**Consultation Response from KC,
Highways Development Management**

2025/91542 Land at, Highmoor Lane, Hartshead Moor, Cleckheaton, BD19 6LW

Erection of 40 dwellings and associated works, including formation of new vehicular access and erection of cricket netting

RECOMMENDATION: Further Information Required

DRAWING TITLE
Proposed Site Layout

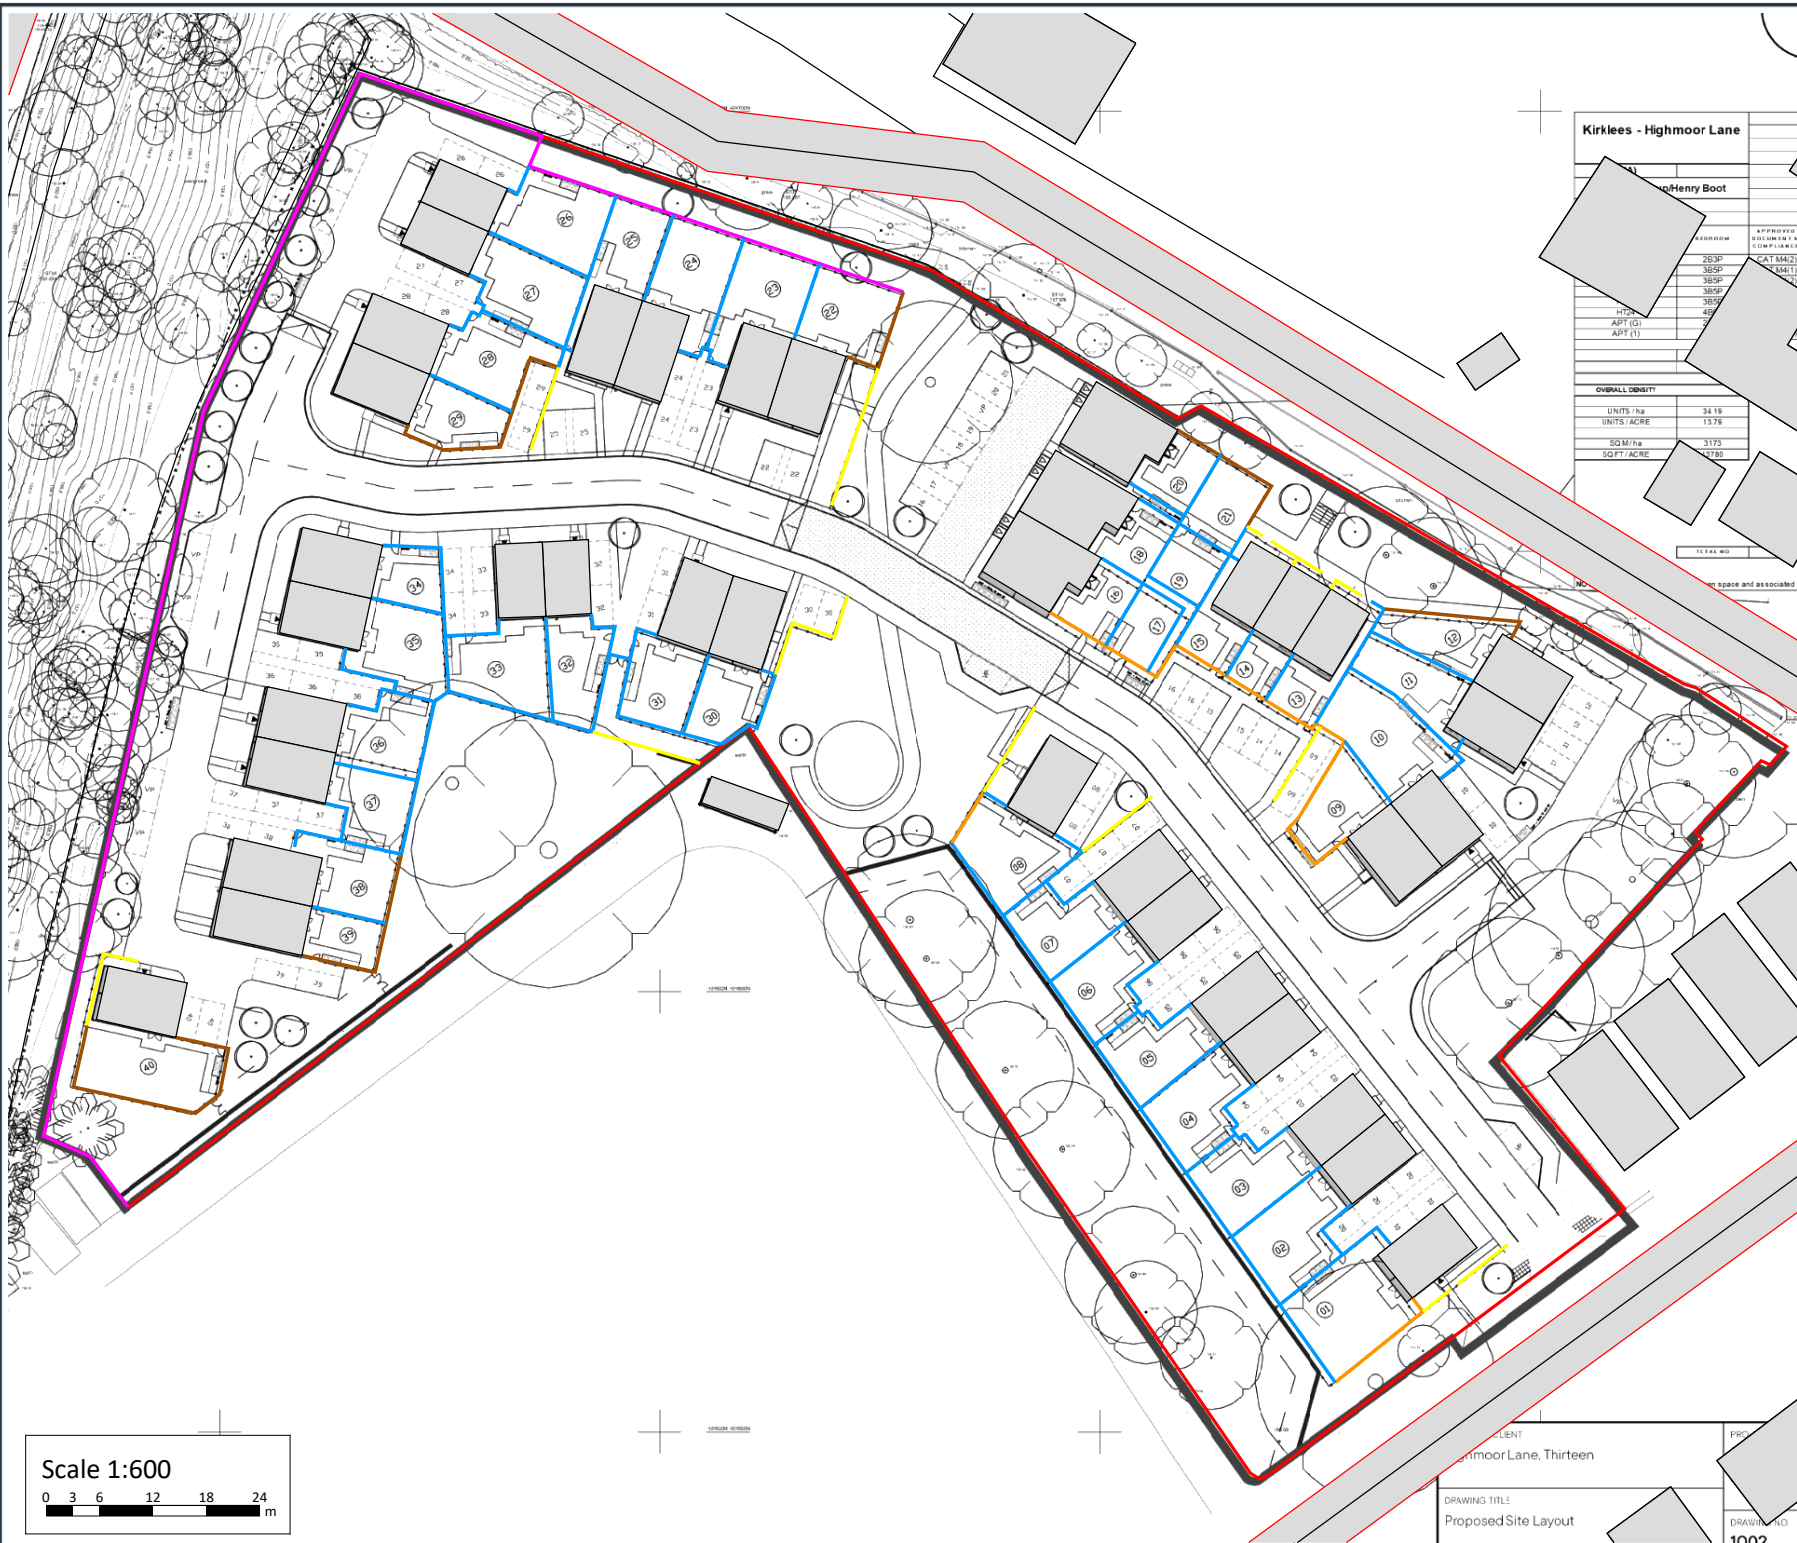
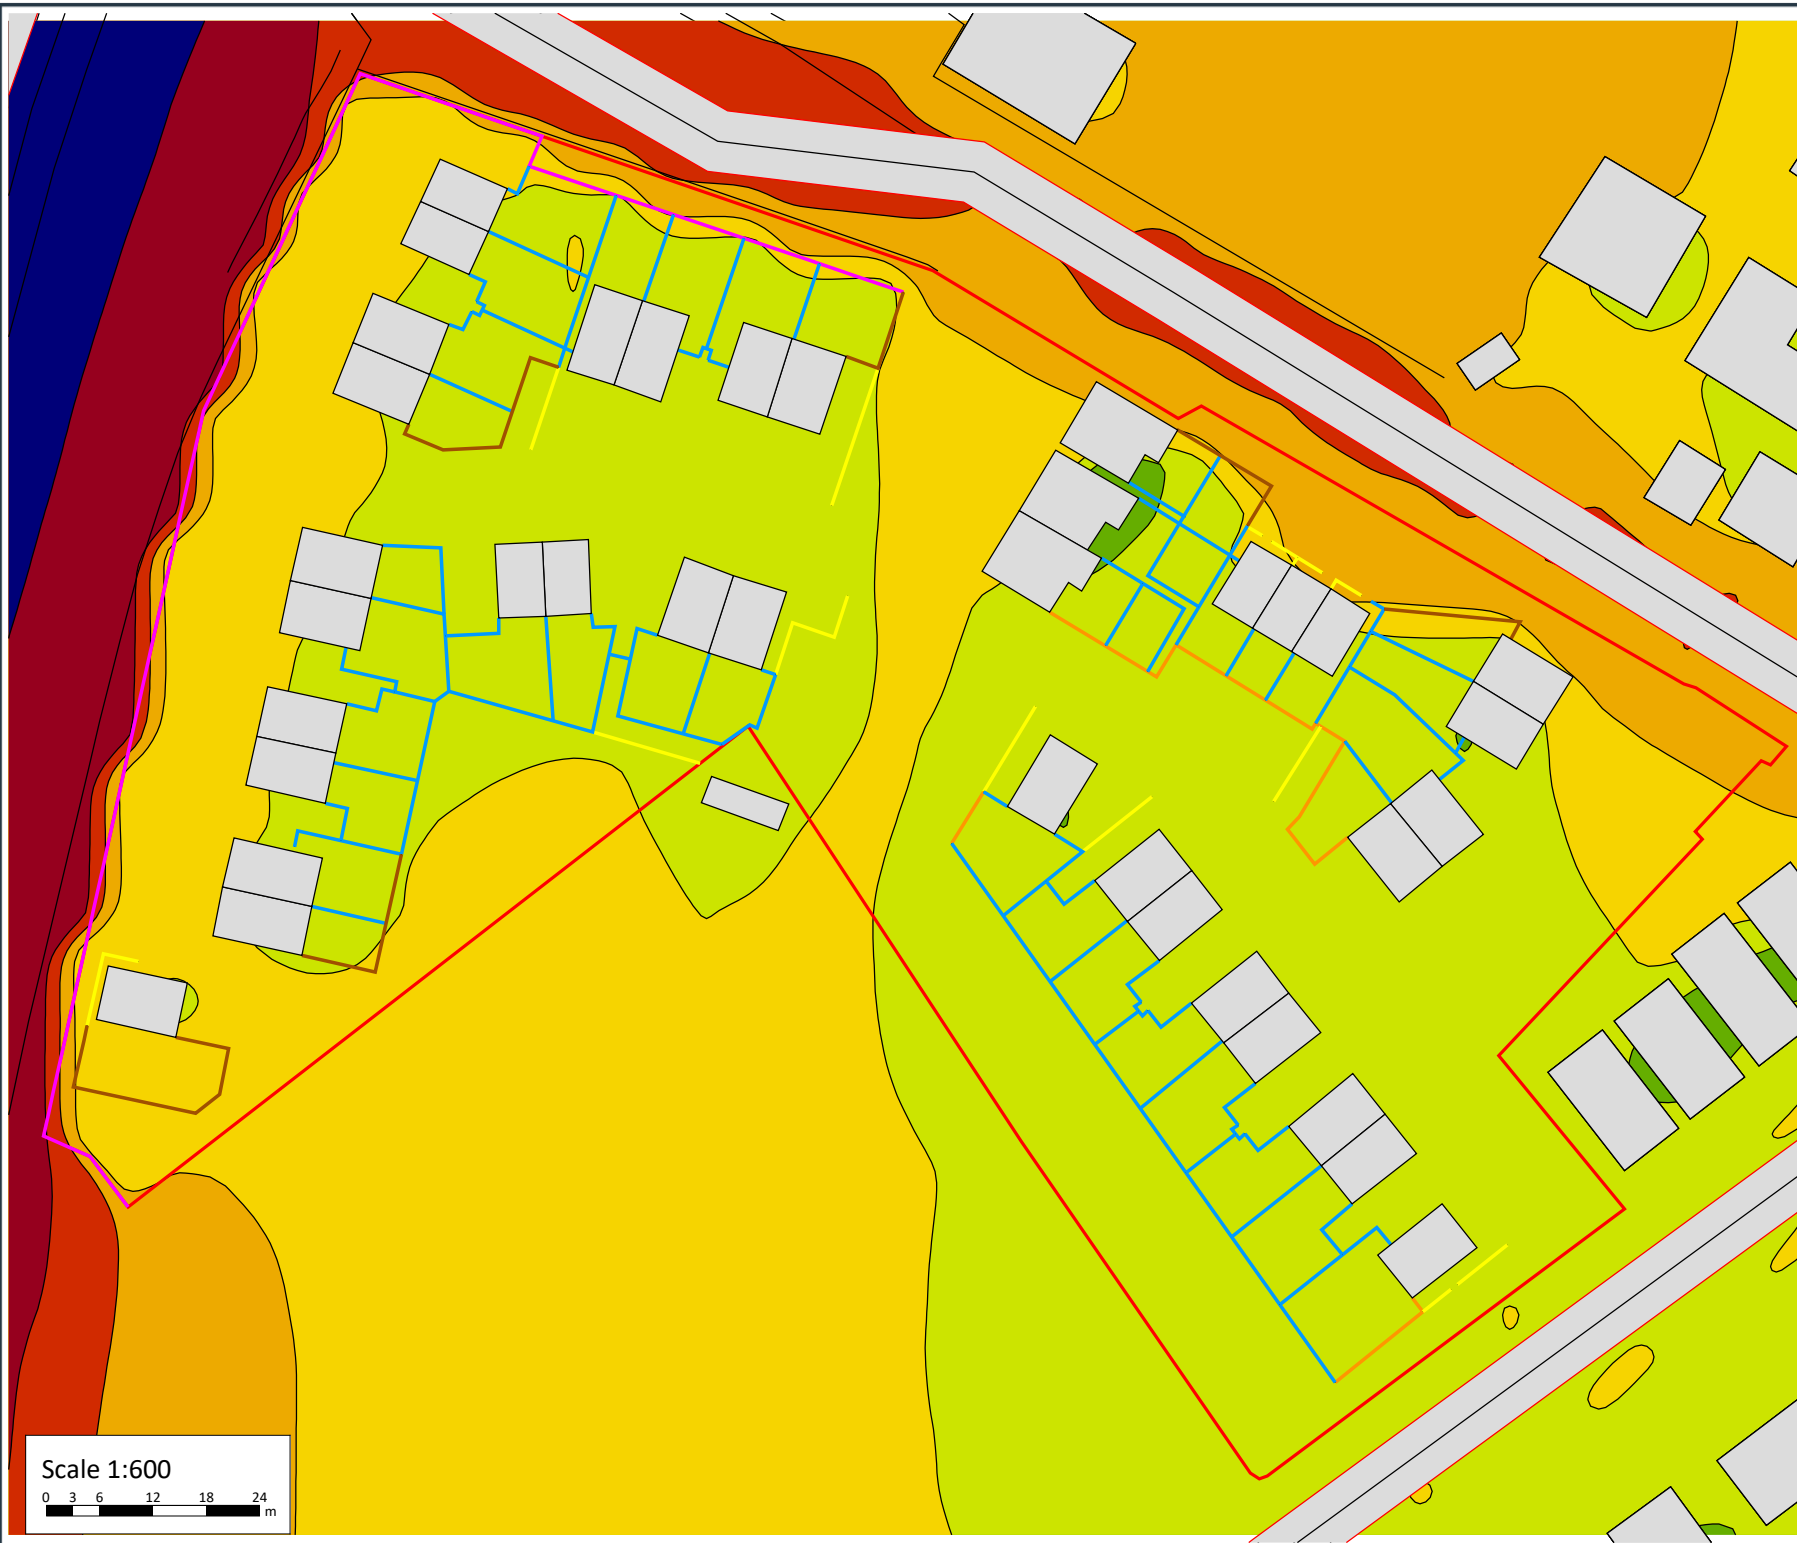
It is noted that a plan has been provided which demonstrates junction and forward visibility splays within the internal layout, it is observed that some of the splays extend over what appears to be private curtilage of dwellings. Amend layout to ensure all visibility splays are contained within the adopted highway.
